# CONSTRUCTION PLANS FOR THE HILLS AT LORSON RANCH FILING NO. 3

## STREET & STORM SEWER CONSTRUCTION PLANS

**THE RIDGE AT LORSON RANCH FIL NO. 3  
STREET & STORM SEWER  
CONSTRUCTION PLANS**

SIGNING AND STRIPING PLAN

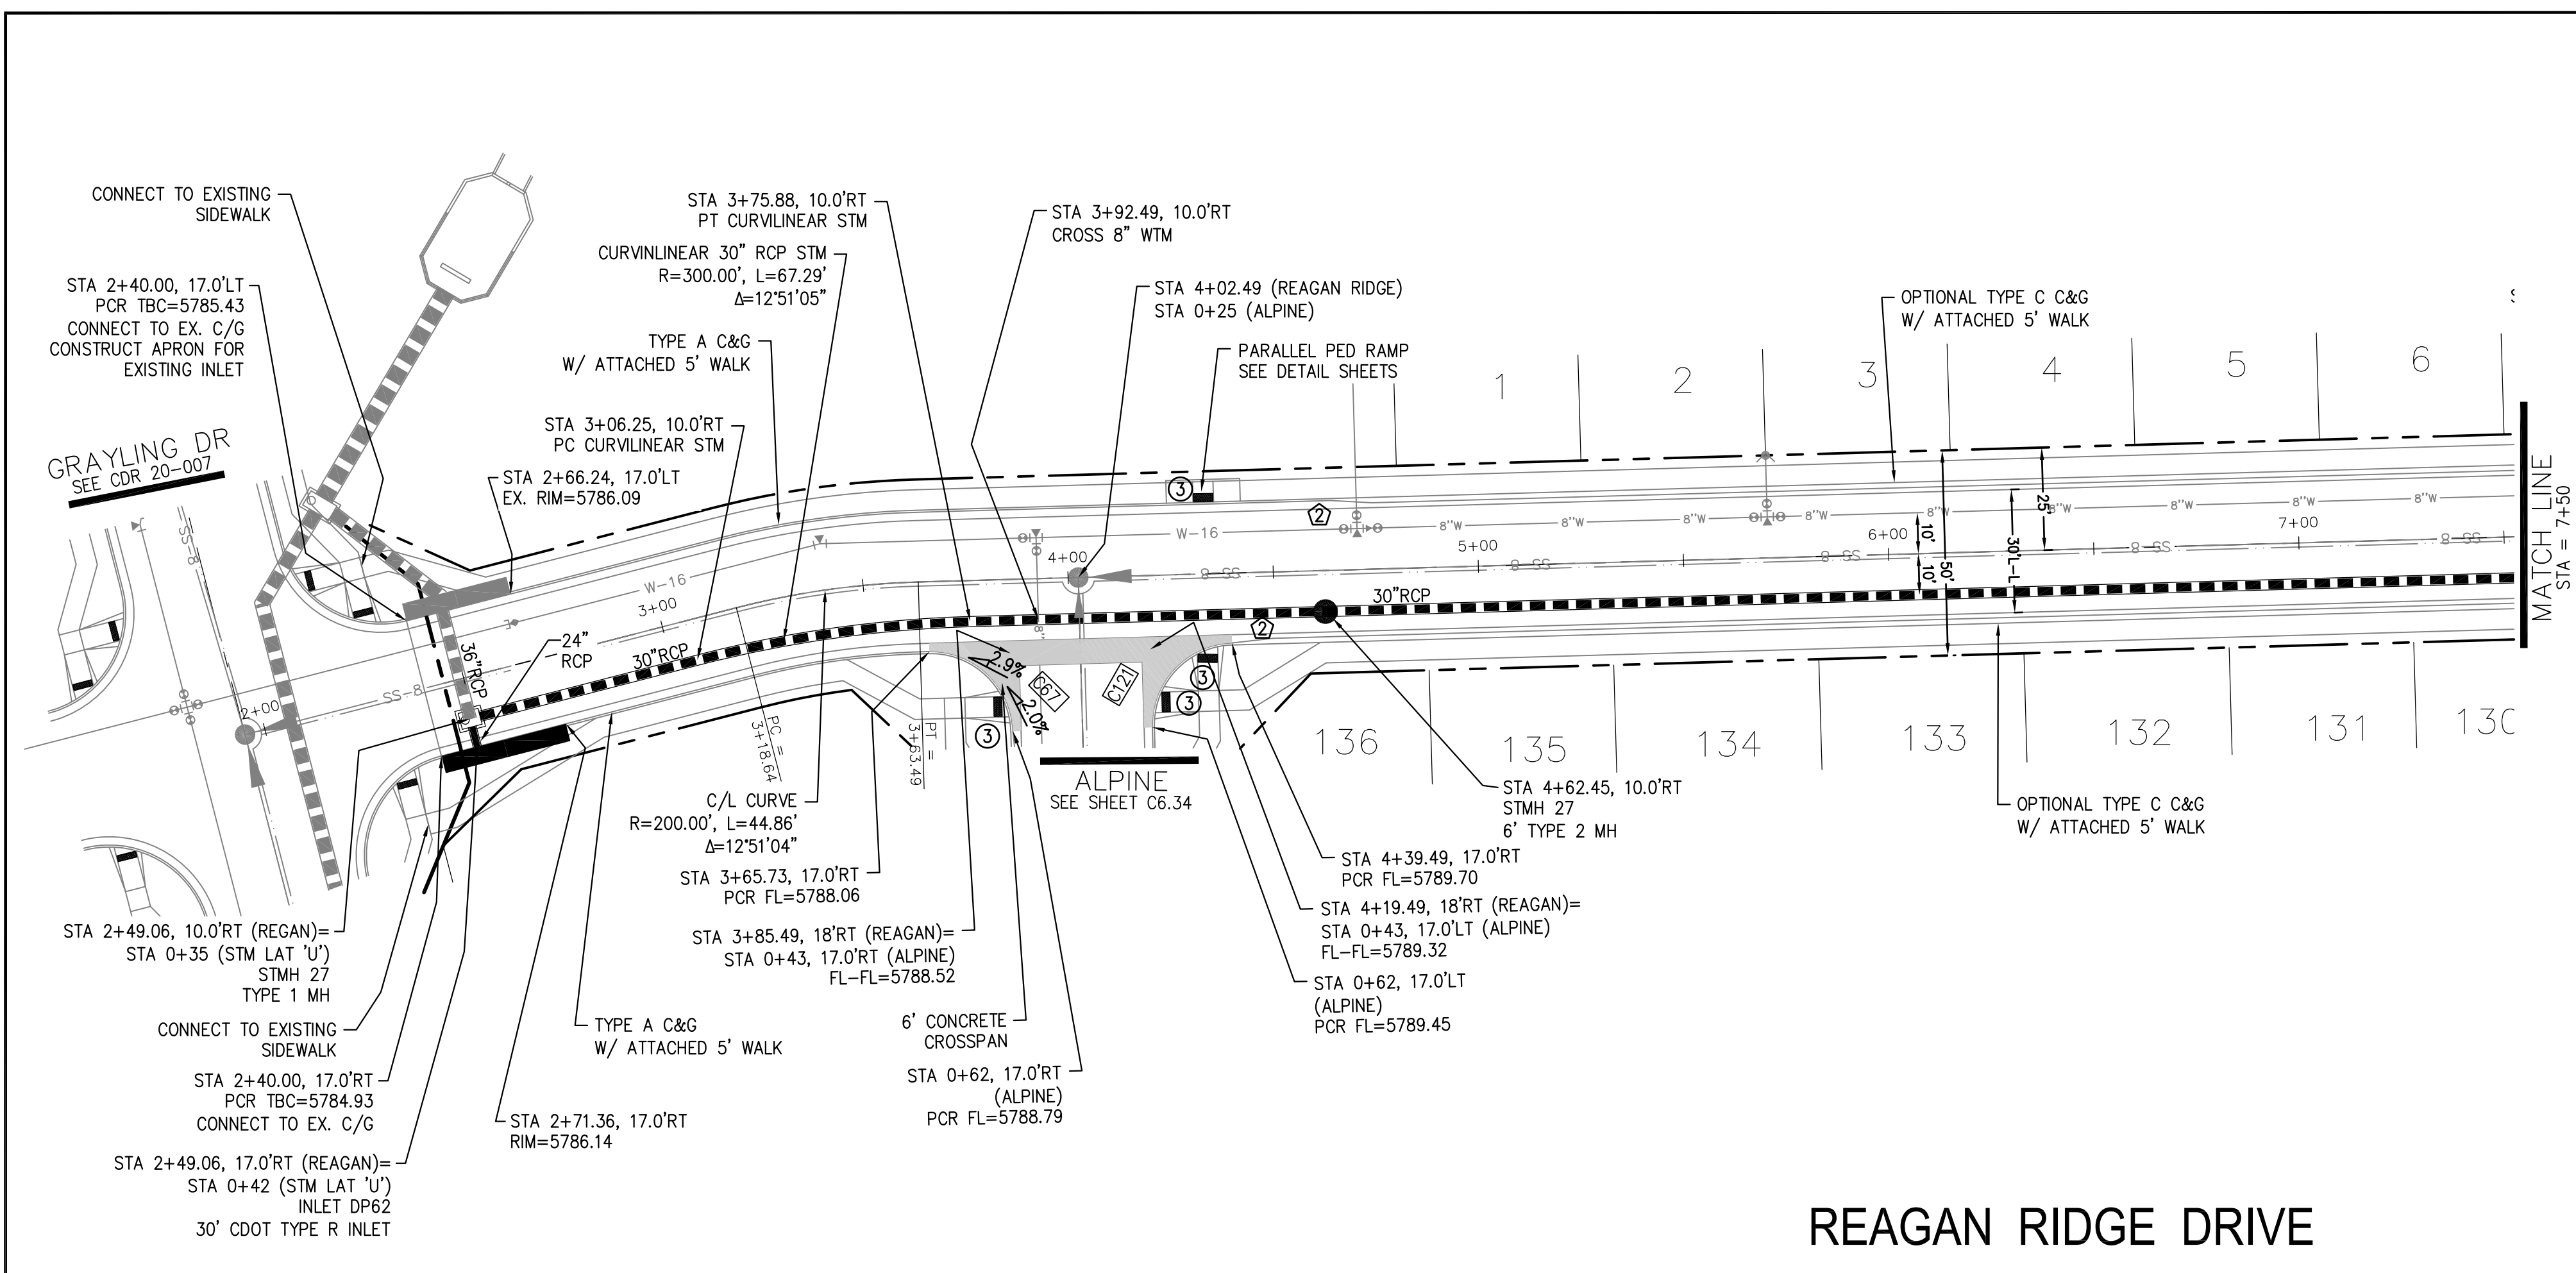
include sizes for all signs.

Provide details for pavement markings or reference CDOT standard striping detail sheet (S-627-1)

Show & label mail kiosk location/easement

DATE: MARCH, 2022
 PROJECT NO. 100.068
 SHEET NUMBER C6.31
 TOTAL SHEETS: 18

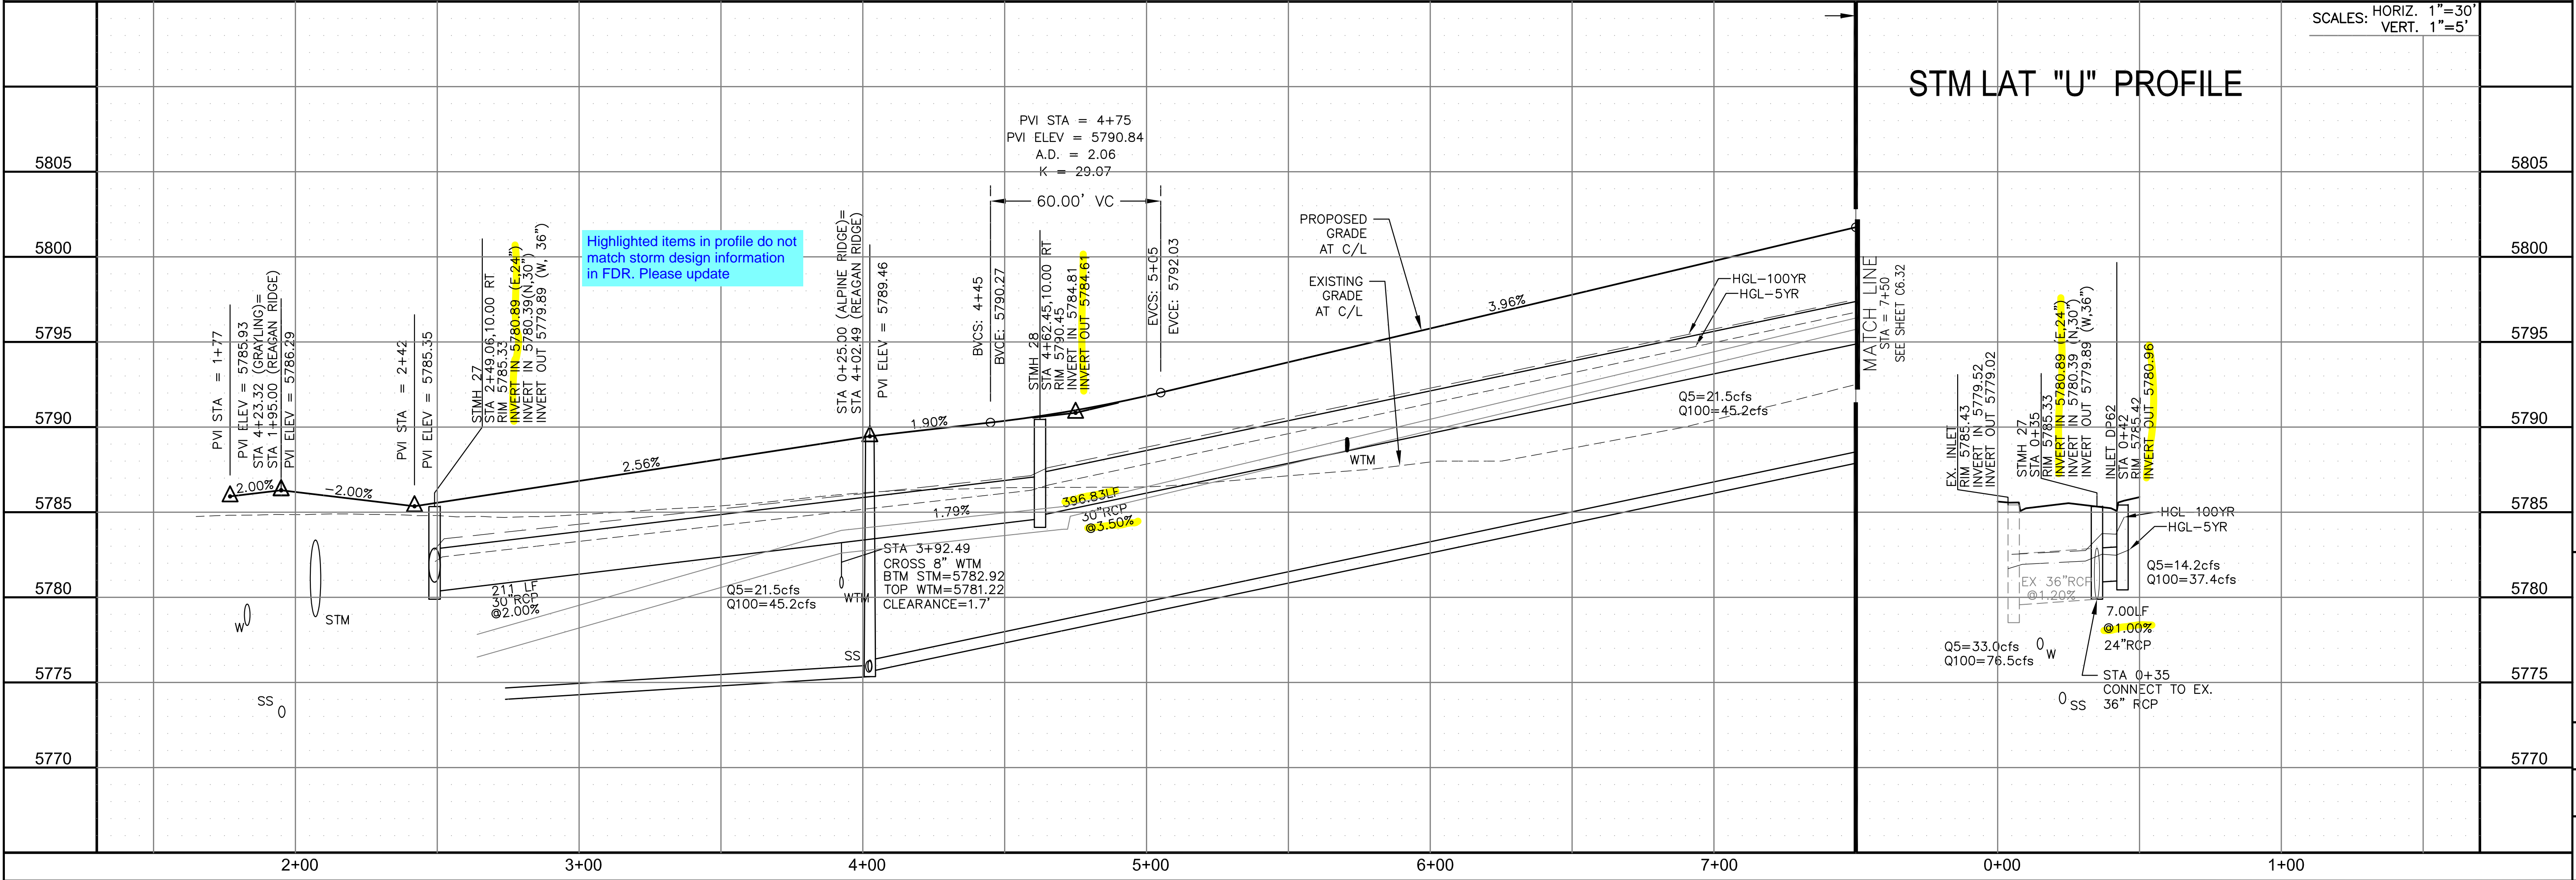
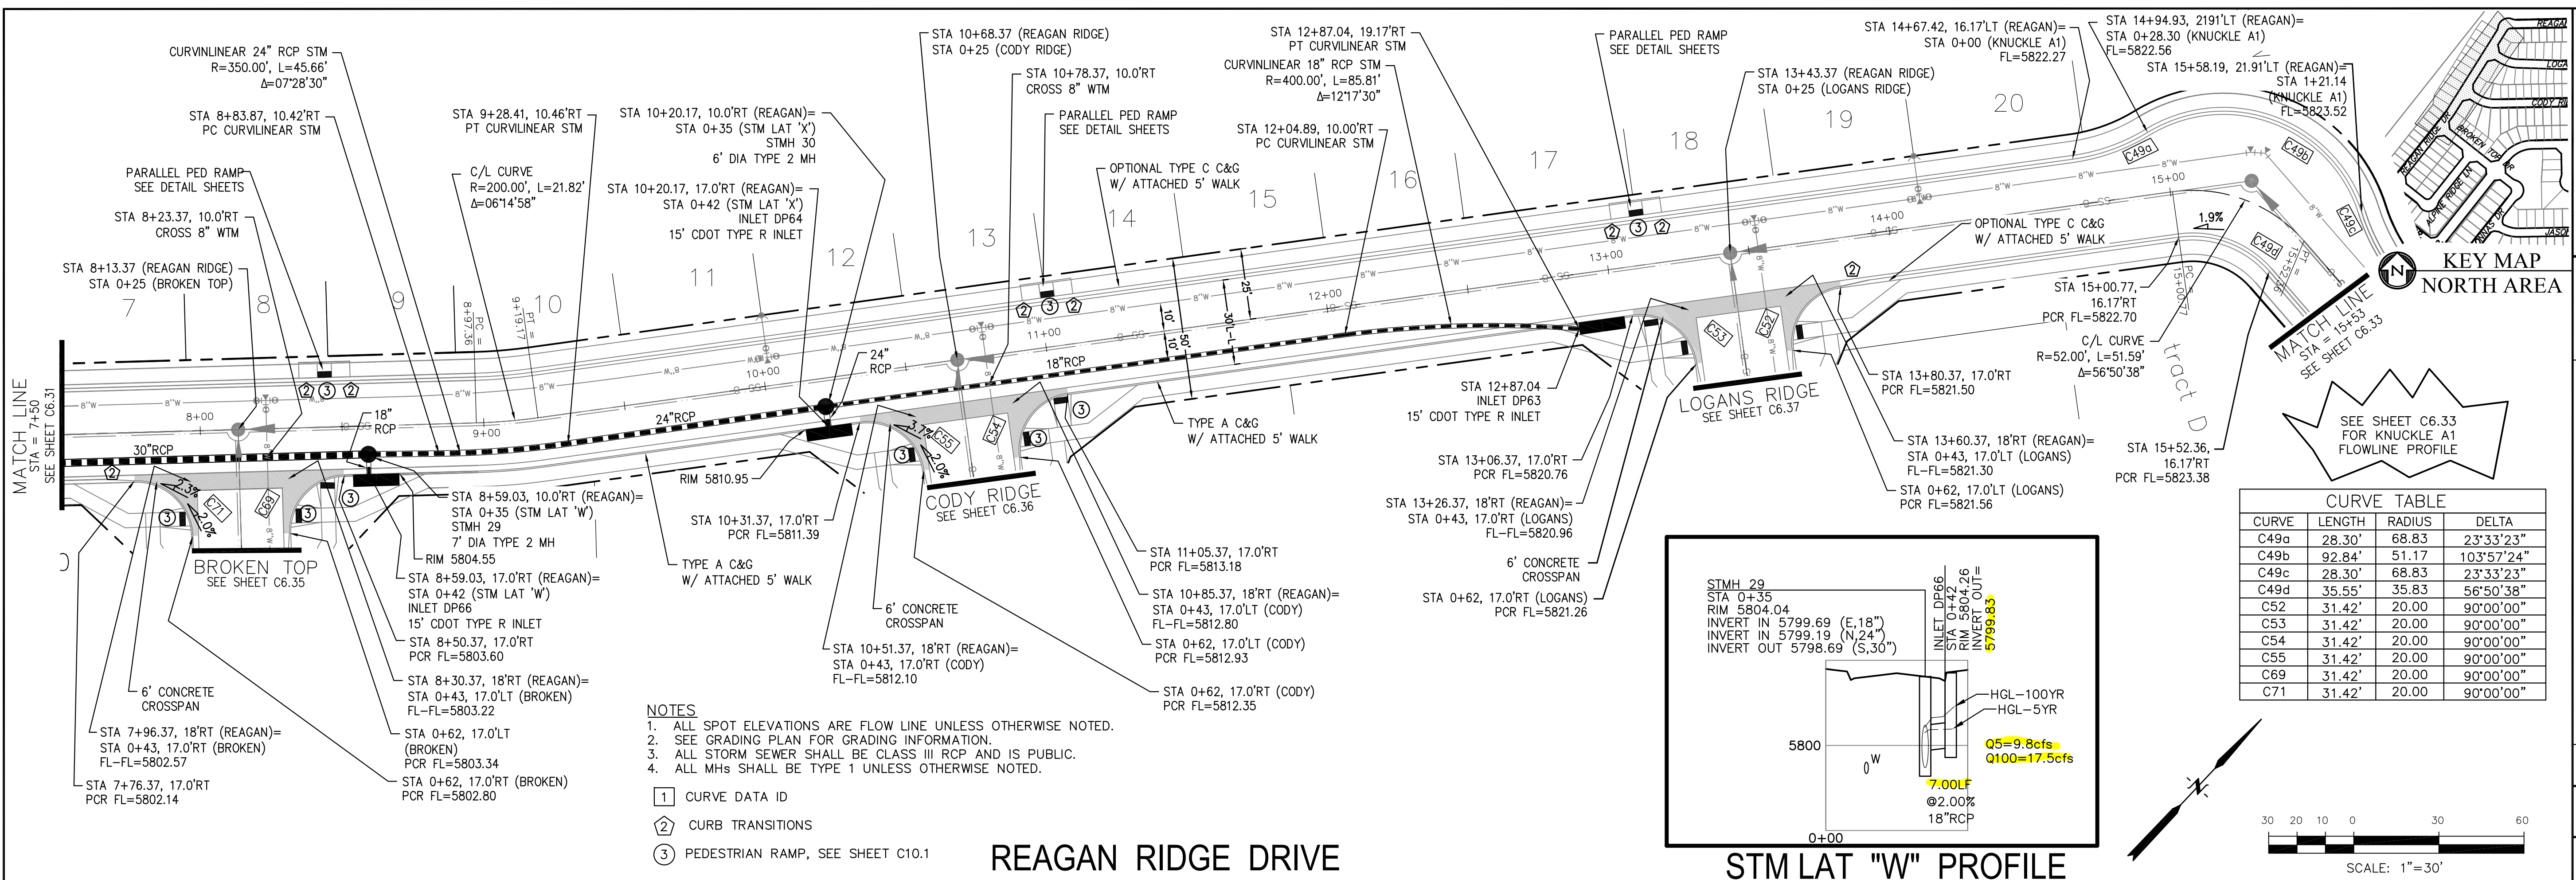
Label all storm facilities at private or public (all sheets)

FDR Inlet spreadsheet shows as a 30' inlet, verify correct size and update accordingly

Update all storm profiles to match information shown in Final Drainage Report
